Application for a non-material amendment following a grant of planning permission. Town and Country Planning Act 1990

ERCTION OF OUTBUILDING TO USE AS GYM/SNOOKER ROOM WITH SHOWER ROOM

17796/APP/2021/3247

Amended Rear Elevation Facing Rear Garden Wall
Scale 1:50 @ A1

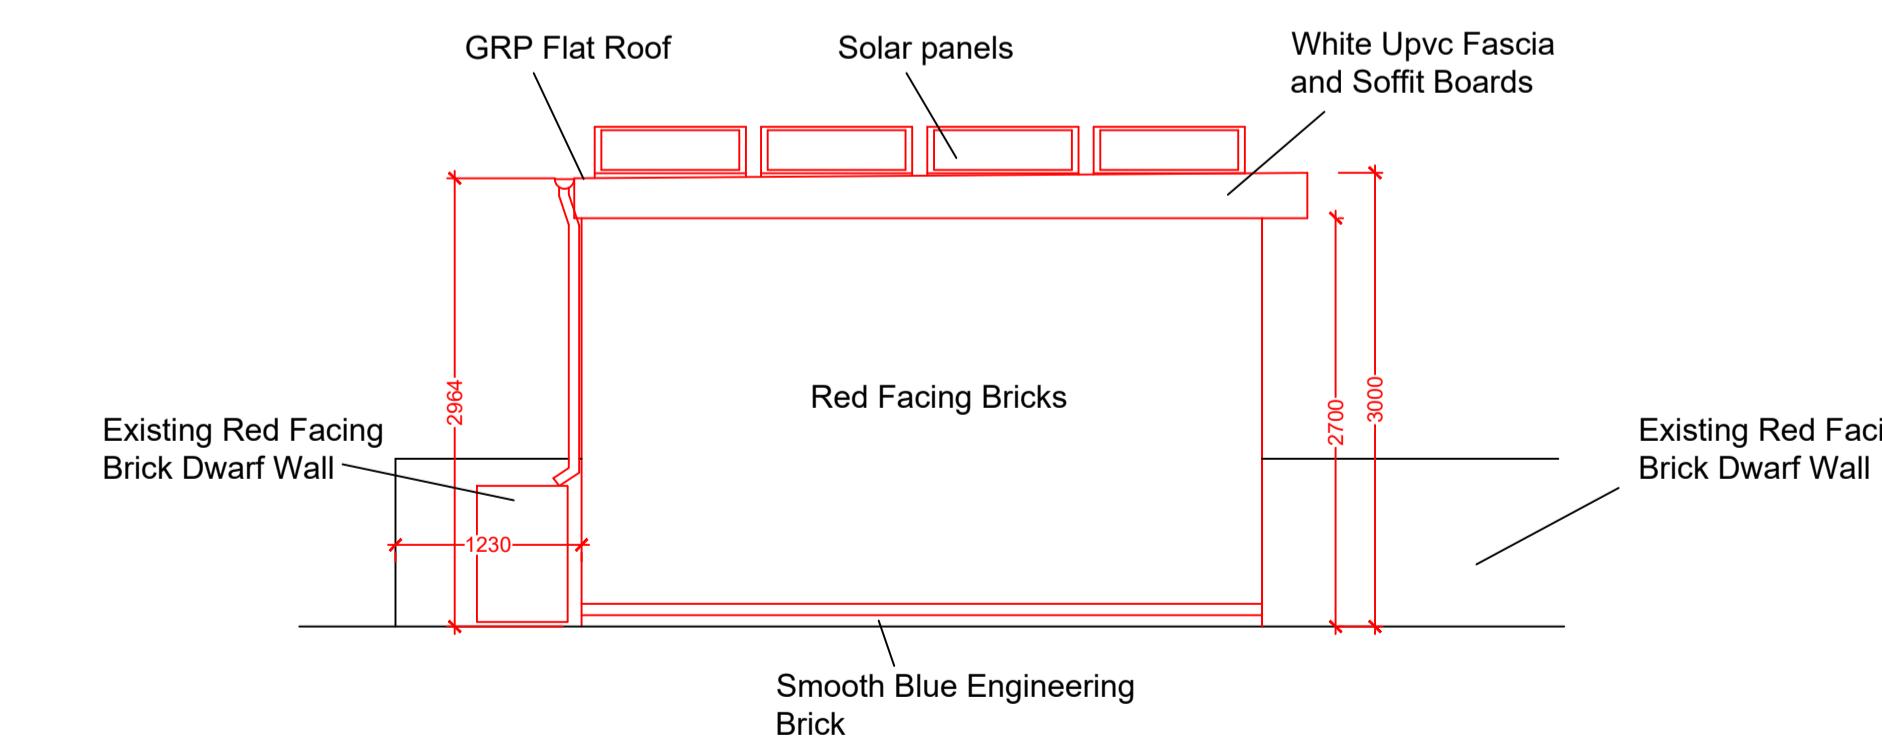
ROOF PRO[REDACTED], ROOF HEIGHT REDUCED, FRONT WINDOW REMOVED, SAUNA AND STEAM ROOM ADDED TO INTERIOR.
